# Consultee Comments for Planning Application 21/02109/FUL

Proposal: Change of use of building to form 1 no. dwellinghouse

Ecology Team Comments

Date: 30/12/2021

TITLE			A2
Proposed site plan			
DRAWN	DATE	SCALE	REVISION
AT	10.08.21	1:500	
DRAWING NO.		REVISION	
1339/01		A

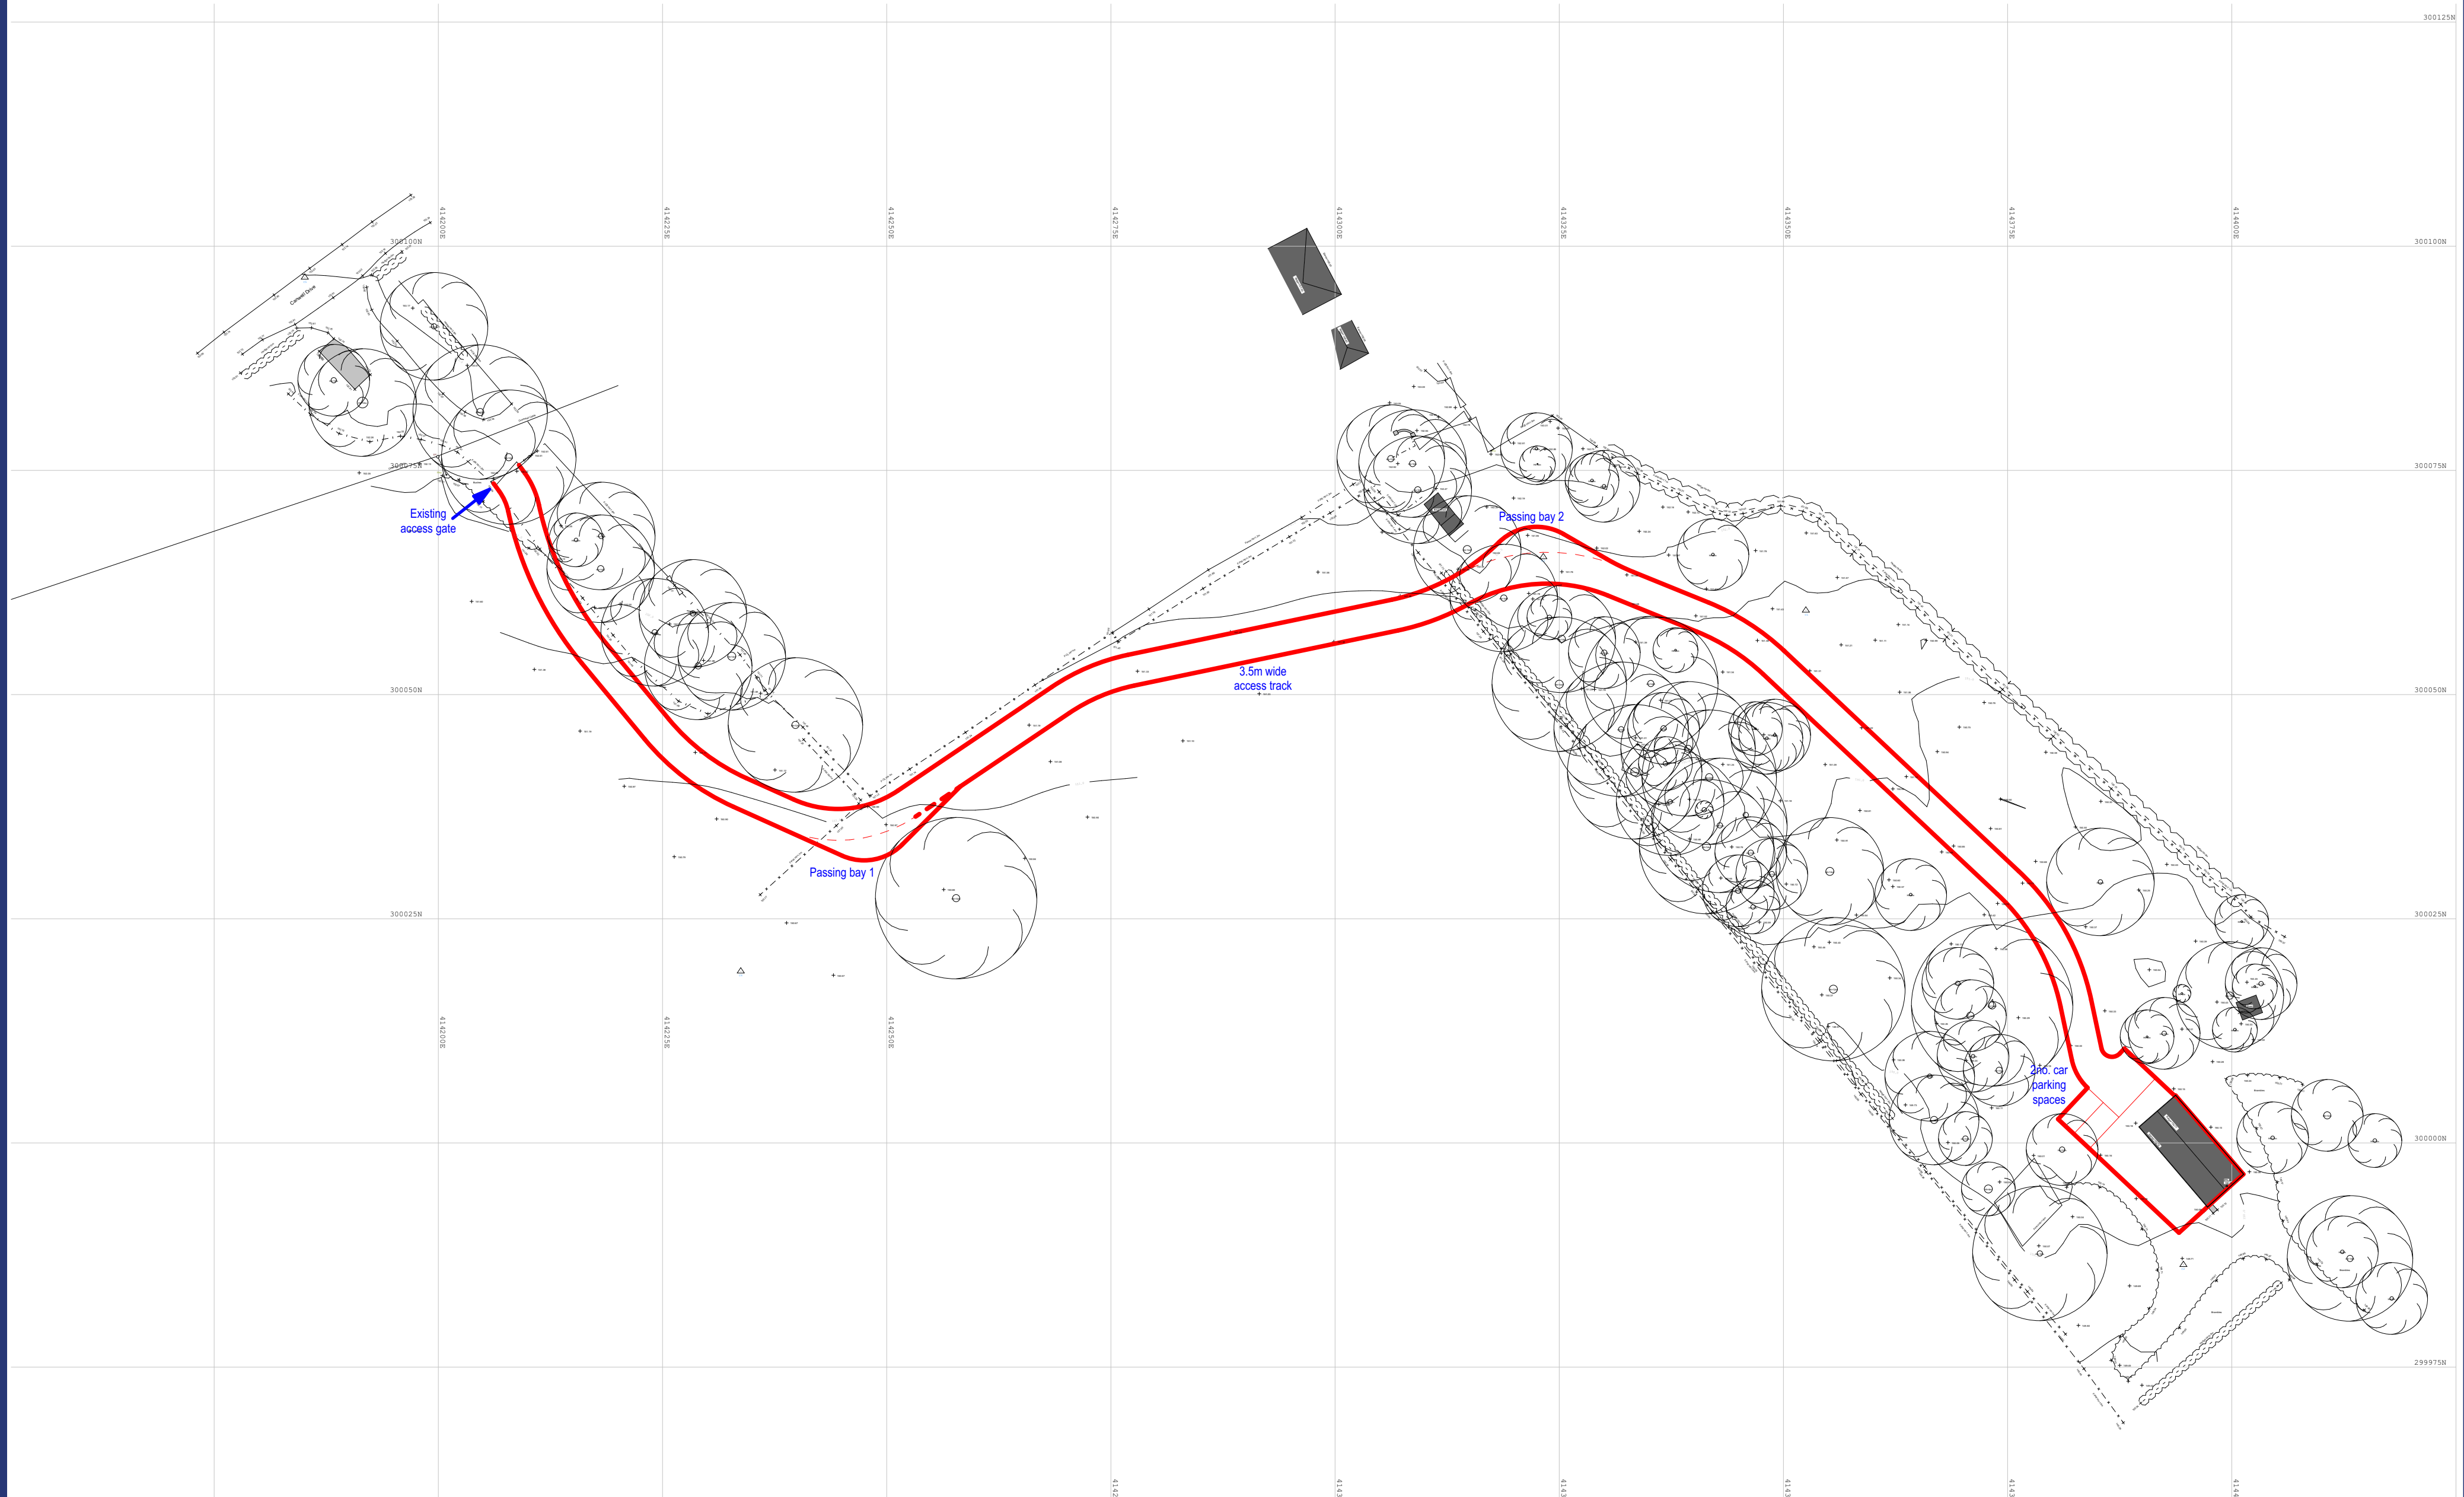
A site plan should be submitted which; details how vehicle movements will be restricted, and designates suitable areas for contractor parking and a contractor compound where materials, fuels and chemicals will be kept and stored. This should be on hard-standing and away from trees, hedgerow and vegetation where possible.

**BAT ACCESS 'SLATE'
DETAIL 1B - with access to
roof void**

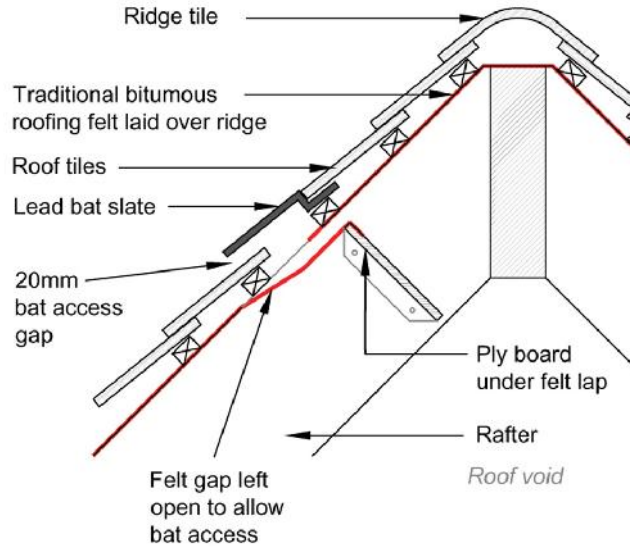
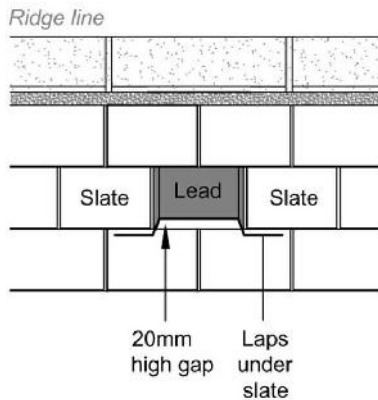
- To compensate for the loss of a hibernation roost for brown long eared bats, a new roof space/bat loft is required. The Ecology Team recommend that out of the two suggestions, that the animal pen is refurbished to create a dedicated bat house. The timber enclosure is to be replaced with brickwork. The roof will be replaced with a new timber structure with a bituminous underfelt and the existing slate roof extended. Access to the building for bats will be created by installing a lead bat slate into the roof (see pages 28-30 for details).
